2023/0638**Applicant:** Ms S Beckett**Address:** 85 The Green View, Shafton, Barnsley, S72 8PW**Description:** Erection of single storey porch to front

PLAN & ELEVATIONS

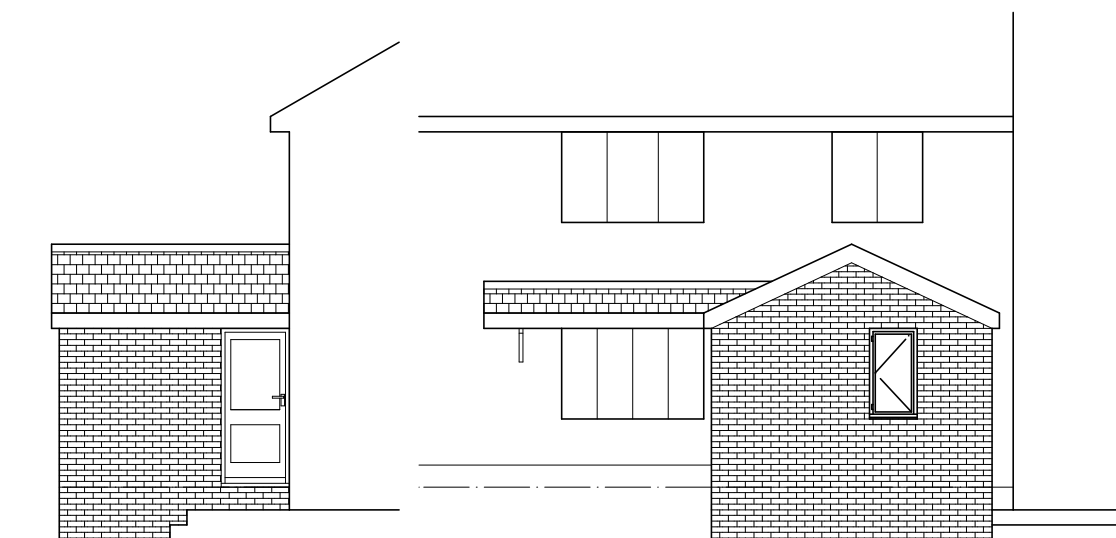
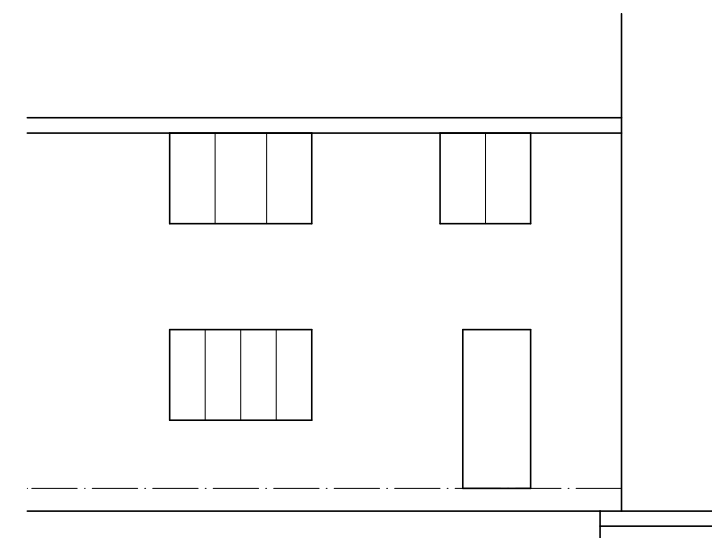
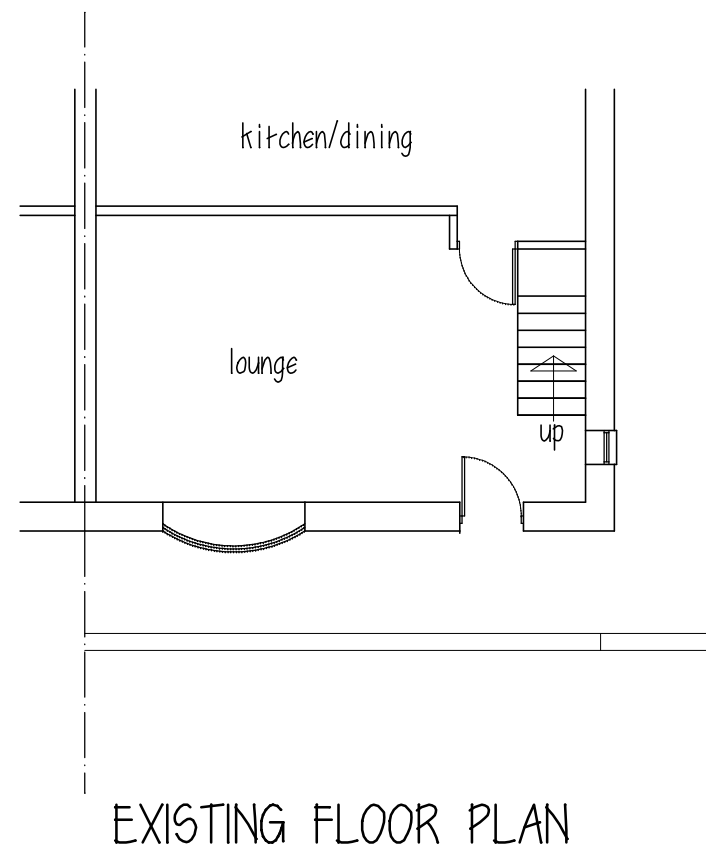
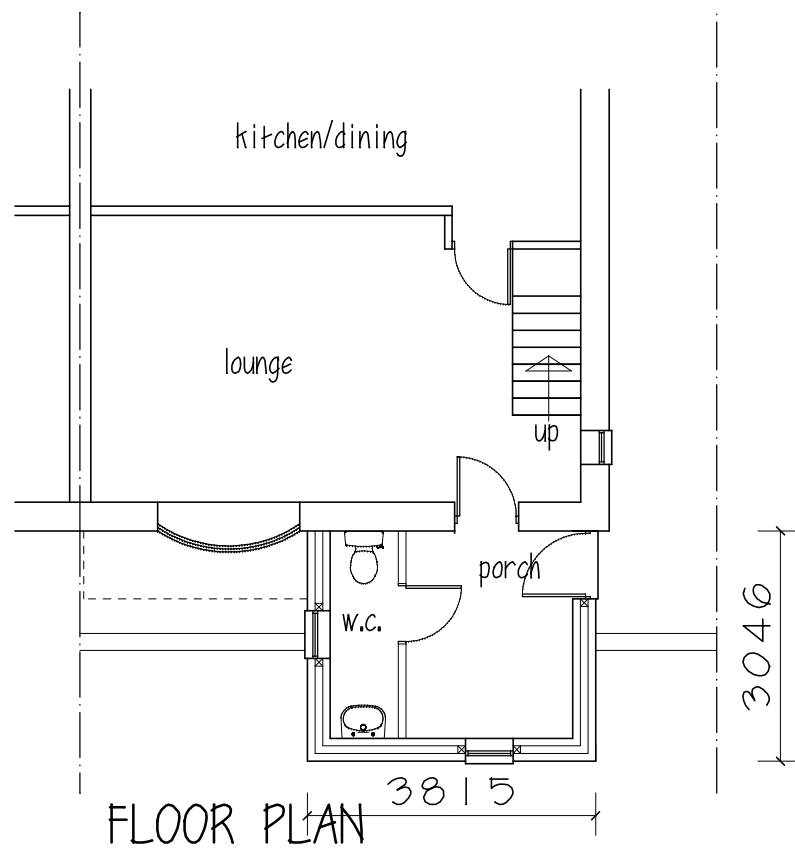
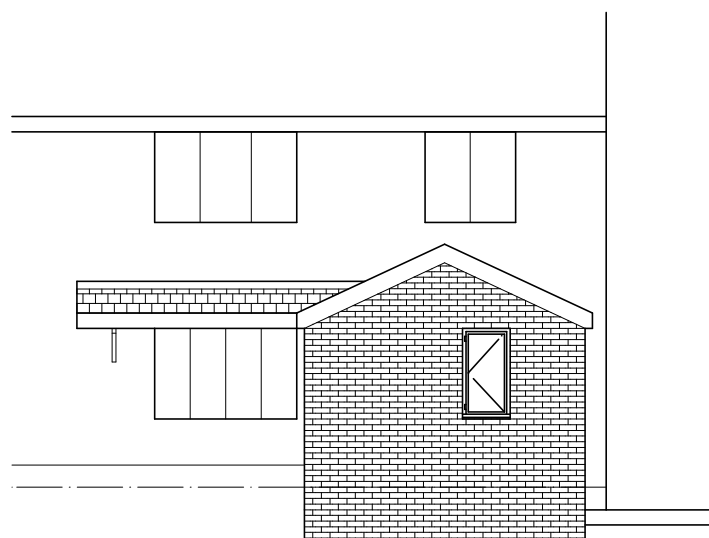
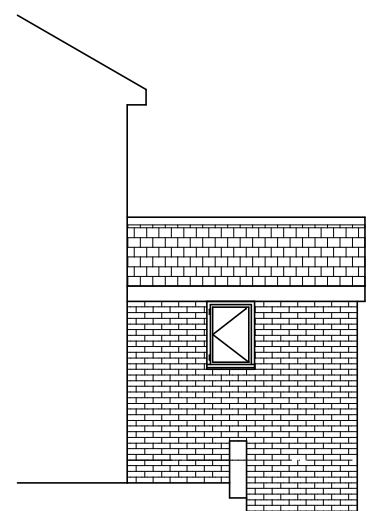
The amended plan includes a larger window on the front elevation as a request for the front door to feature on the front elevation was declined for technical difficulties in achieving this. The application form confirm that the extension would be constructed of similar materials brick, concrete roof tiles and UPVC windows.

The size and style of the porch or canopy would not harm the character of the dwelling or the area. Whilst not abundant in the area some dwellings on the street have porches and a few more have canopies. A front door featuring on the front elevation of the porch may have been more balancing, but the amended plans do include a larger window than originally proposed, making the porch more visually acceptable.
